The Administrative Authorization for 51 Congress Street was denied by Shukria Wiar, Planner on October 24, 2011 because the proposed structure does not meet zoning, please see attached letter.

Re: 51 Congress Street – 014 K009 – R-6- deck – permit #09-0847

PROPOSED DECK AT
51 CONGRESS STREET
IN PORTLAND, MAINE

**PROPOSED DECK AT
51 CONGRESS STREET
IN PORTLAND, MAINE**
PAGE 2 OF 2
By Anthony Taylor
in consultation with
Joseph H. Leasure, P.E.
JULY 10, 2009

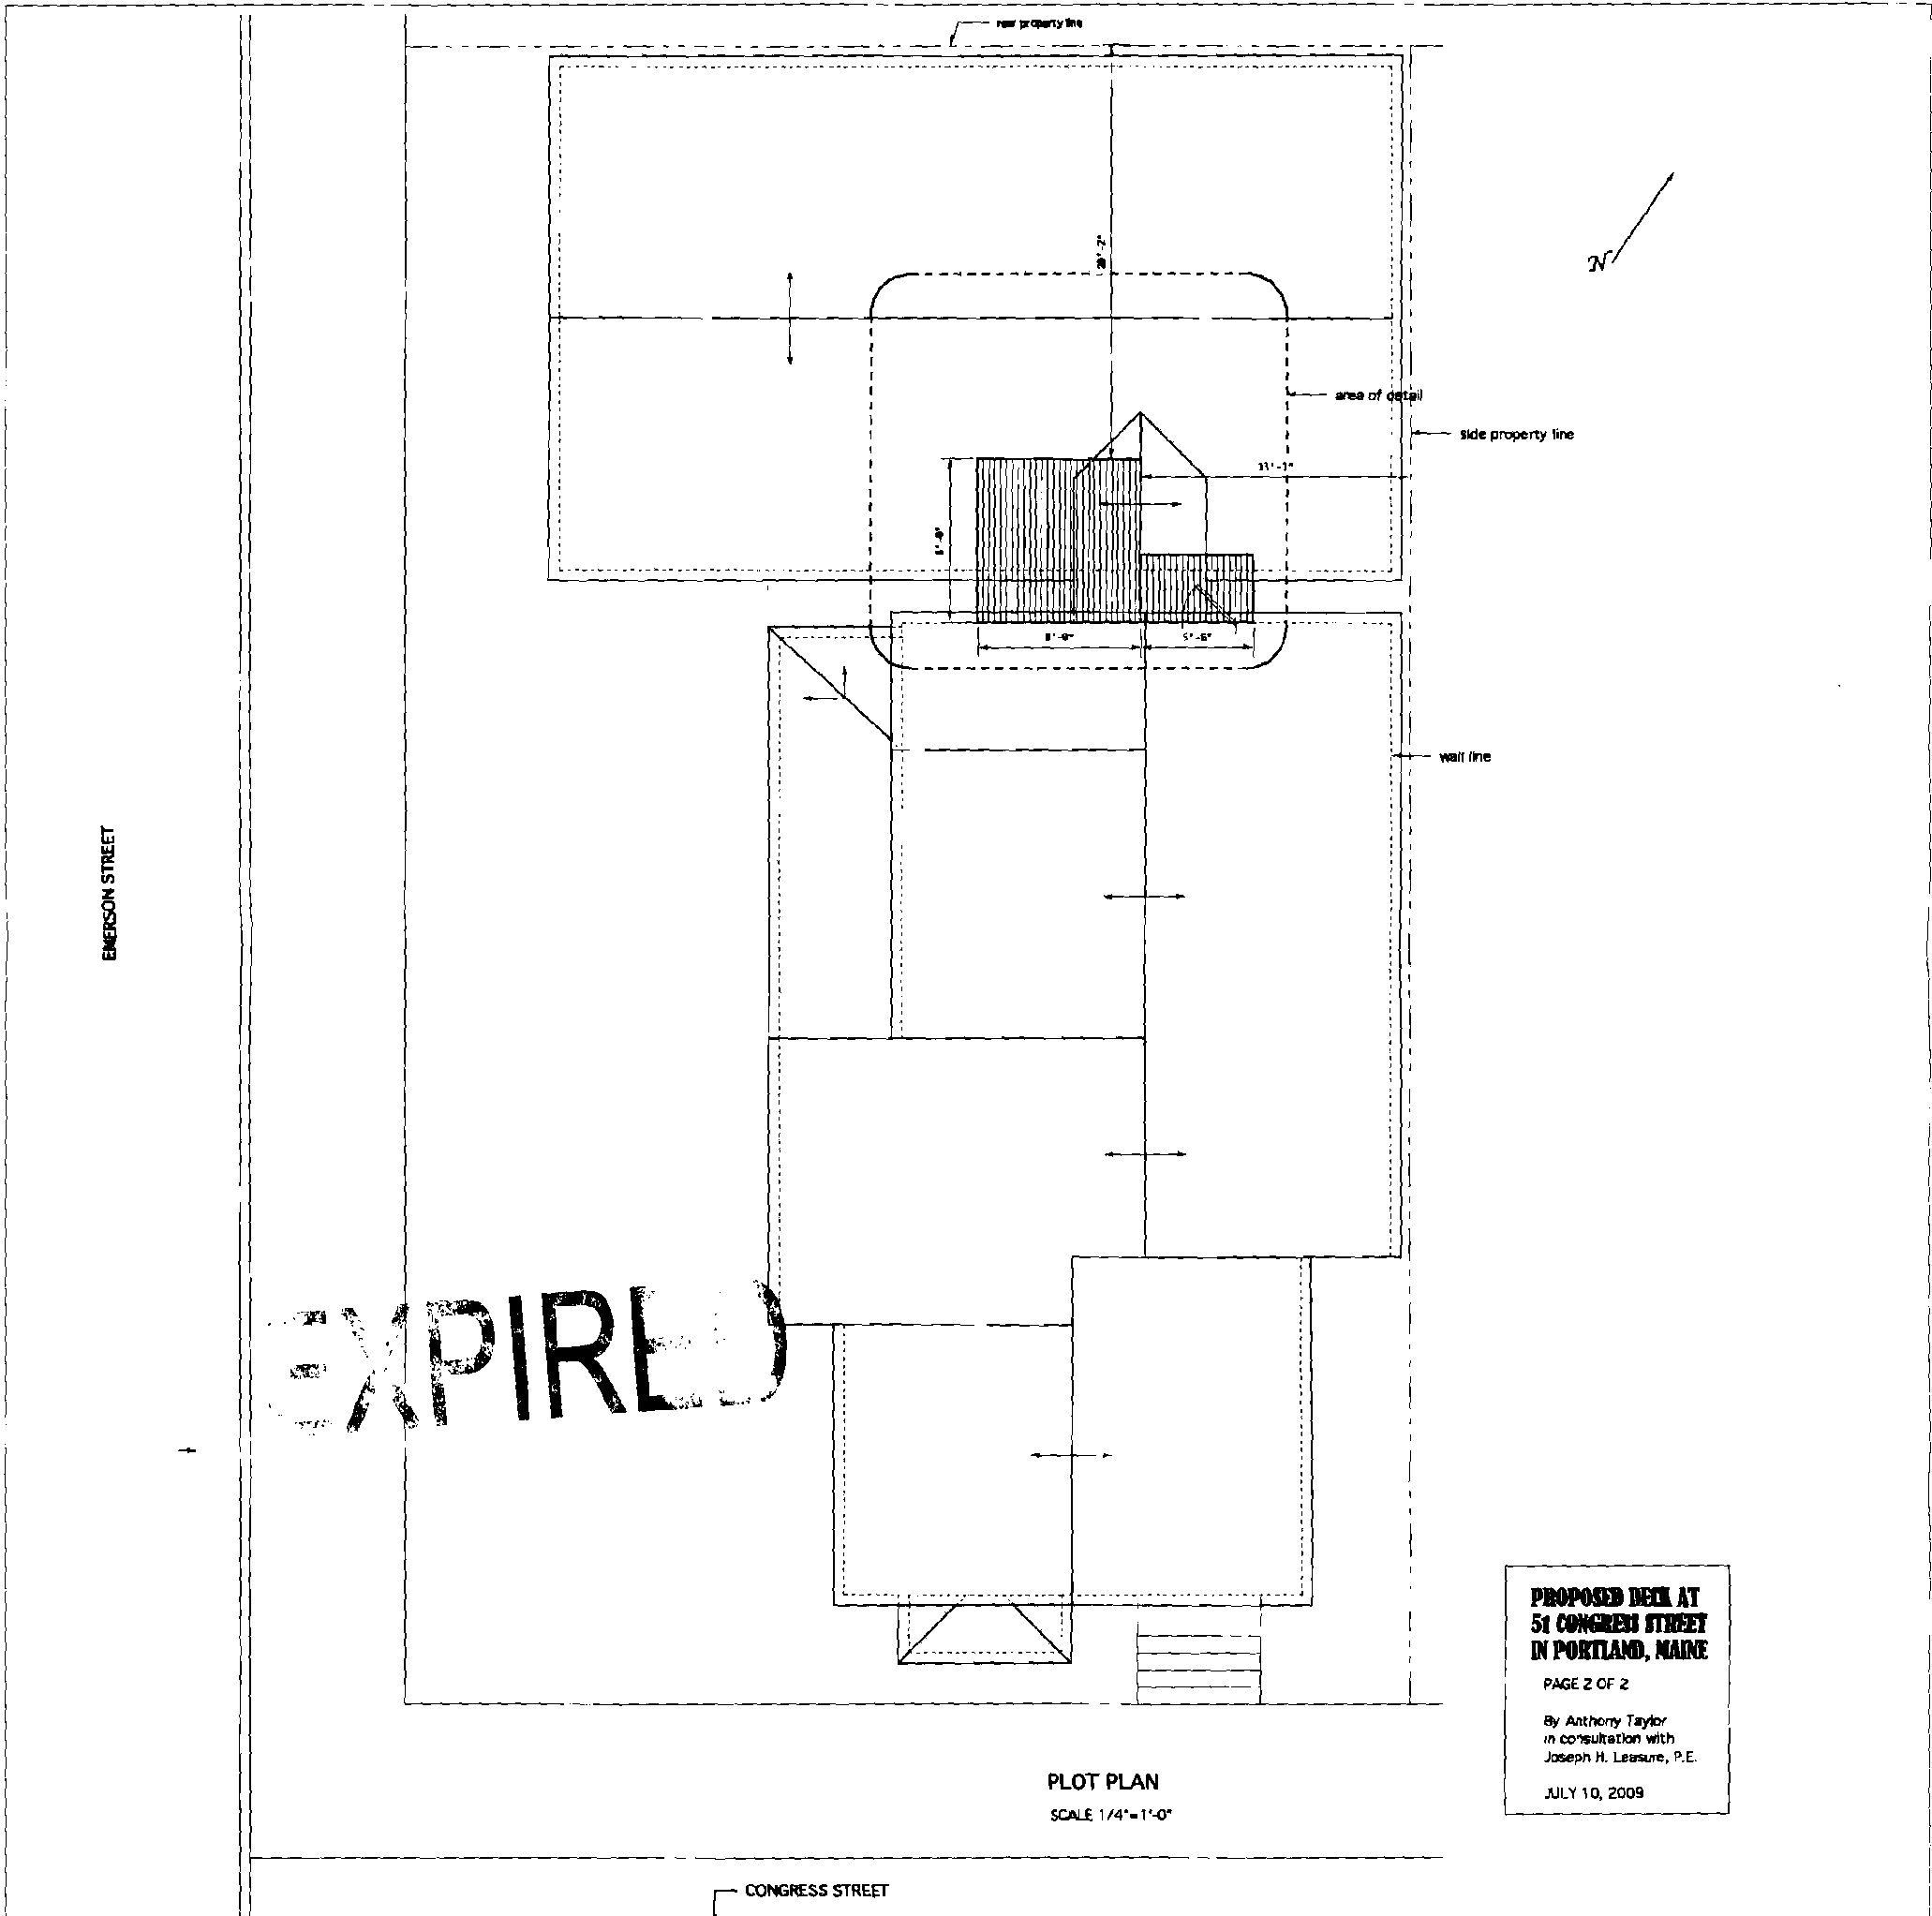
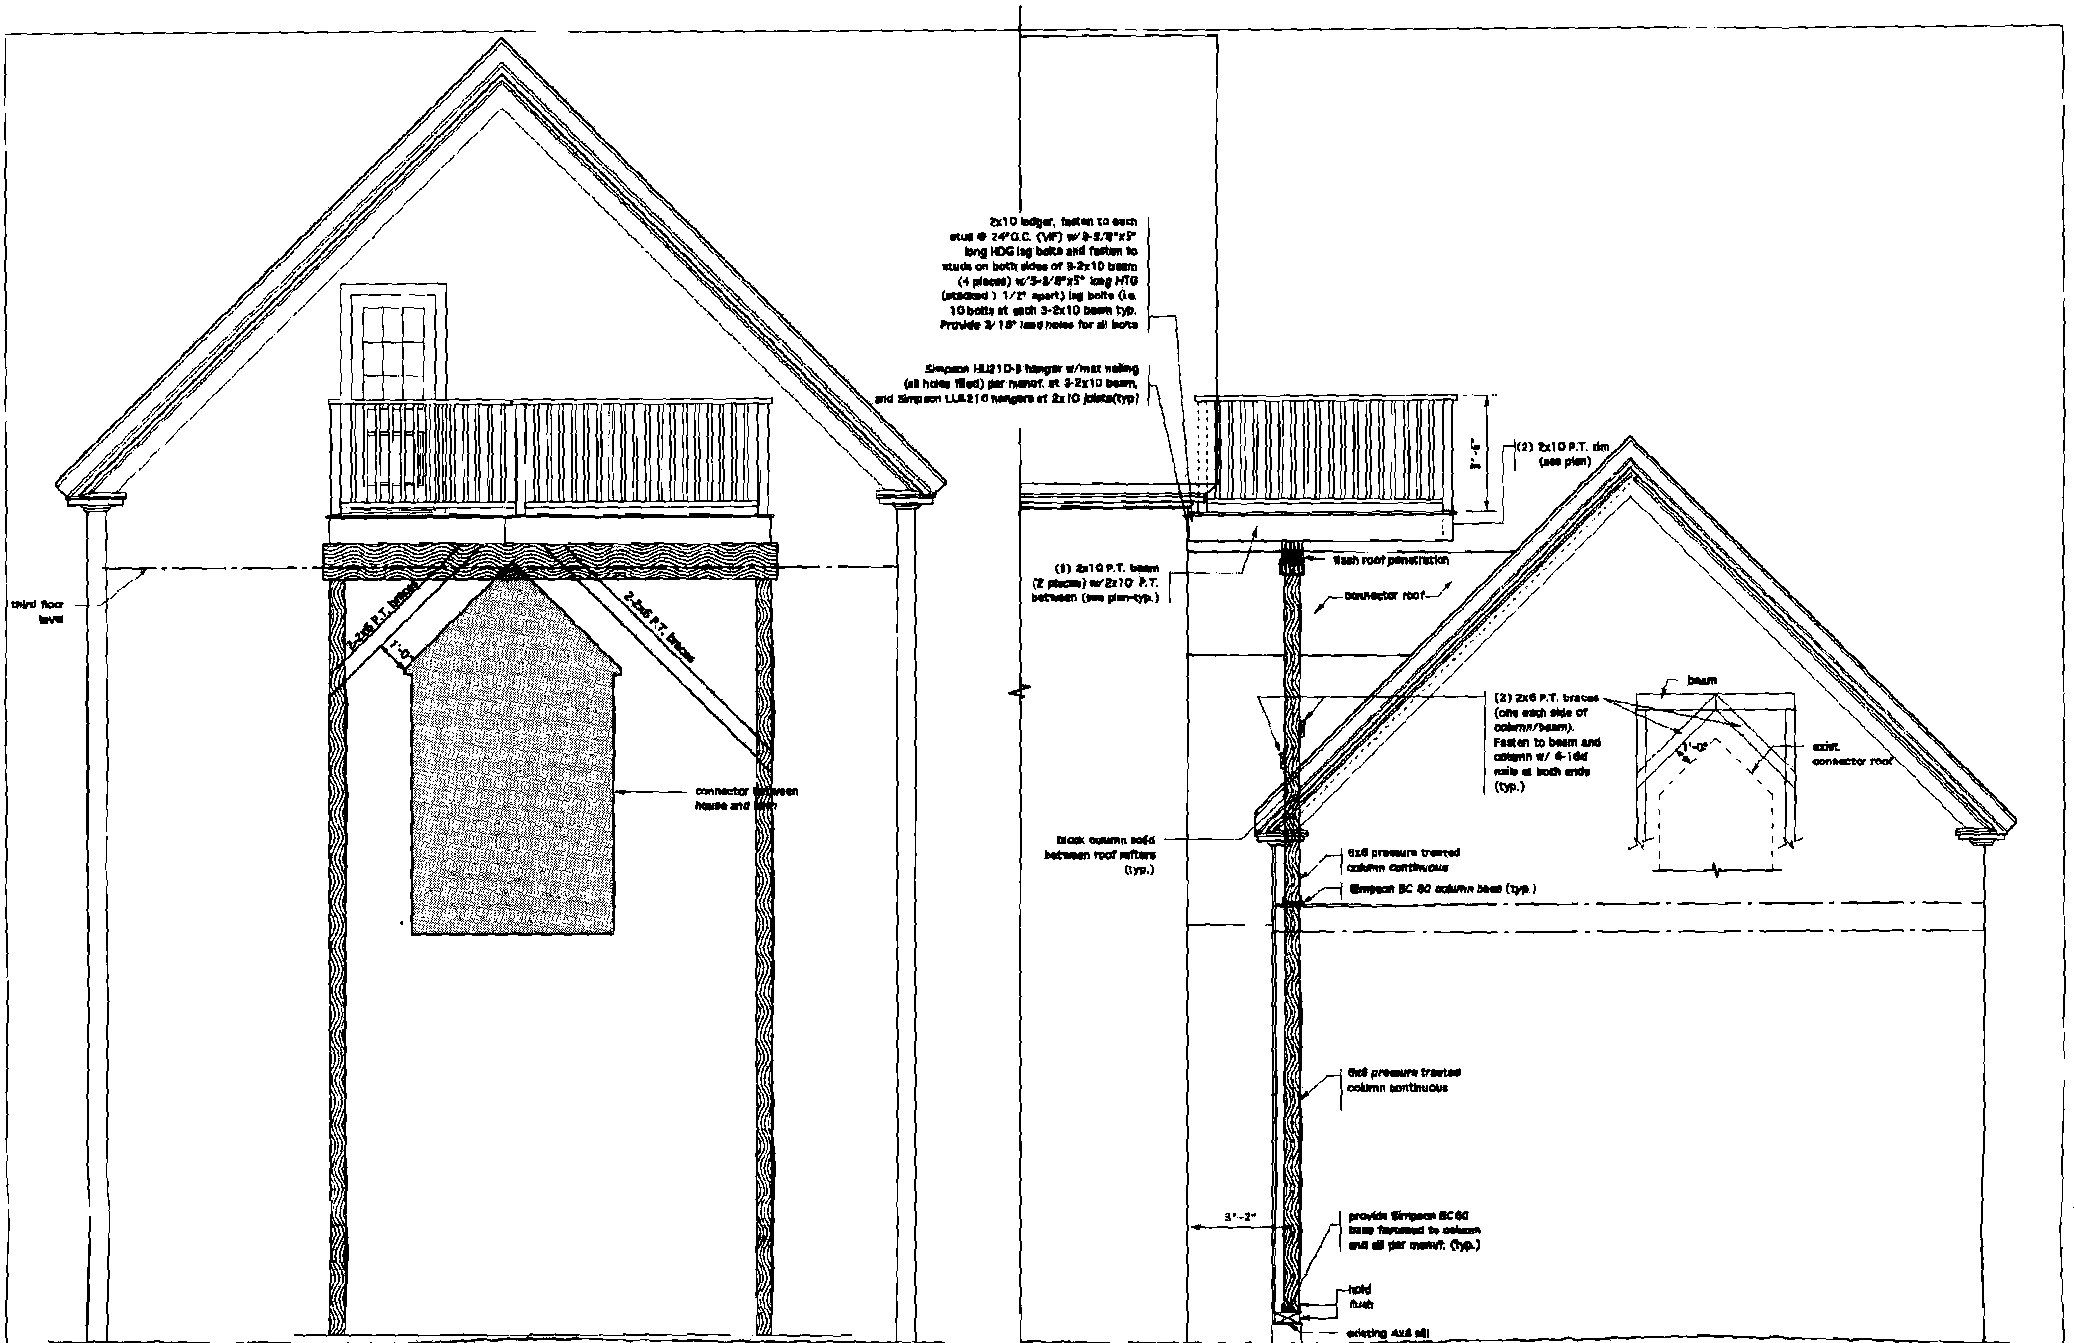
I have reviewed the building application to add an 8'x 8' deck and a 3'6" x 5'6" landing off the third floor of the rear of the building extending over the existing barn. The proposed addition does not meet the lot coverage, so I must deny the application.

51 Congress Street is located in the R-6 residential zone. Section 14-139(d)(3) gives the side setback for a three story structure as 10'. The setback given for the distance from the right side property line to the proposed landing is 9'. Although 10' is required, section 14-433 allows the side setback to be reduced to 5' for an addition if the principal structure existed as of July 19, 1988 and the normal applicable yard requirements can't be met. Since the landing needs to be at 9' because of the existing conditions of the third floor, the side setback can be reduced to 9' under section 14-433.

Section 14-139(e) gives the maximum amount of lot coverage as 50%. The lot is 3960 square feet, so 1980 square feet of the lot can be covered by the footprint of any structure. The total footprint of the existing structures is 2296.78 square feet which is 316.78 square feet over the maximum allowable lot coverage. It covers 57.9% of the lot. The proposed deck and landing would add 24.22 square feet to the footprint for a total of 2321 square feet which covers 58.6% of the lot. Since the proposed lot coverage is over the maximum allowable lot coverage of 50%, I must deny the permit.
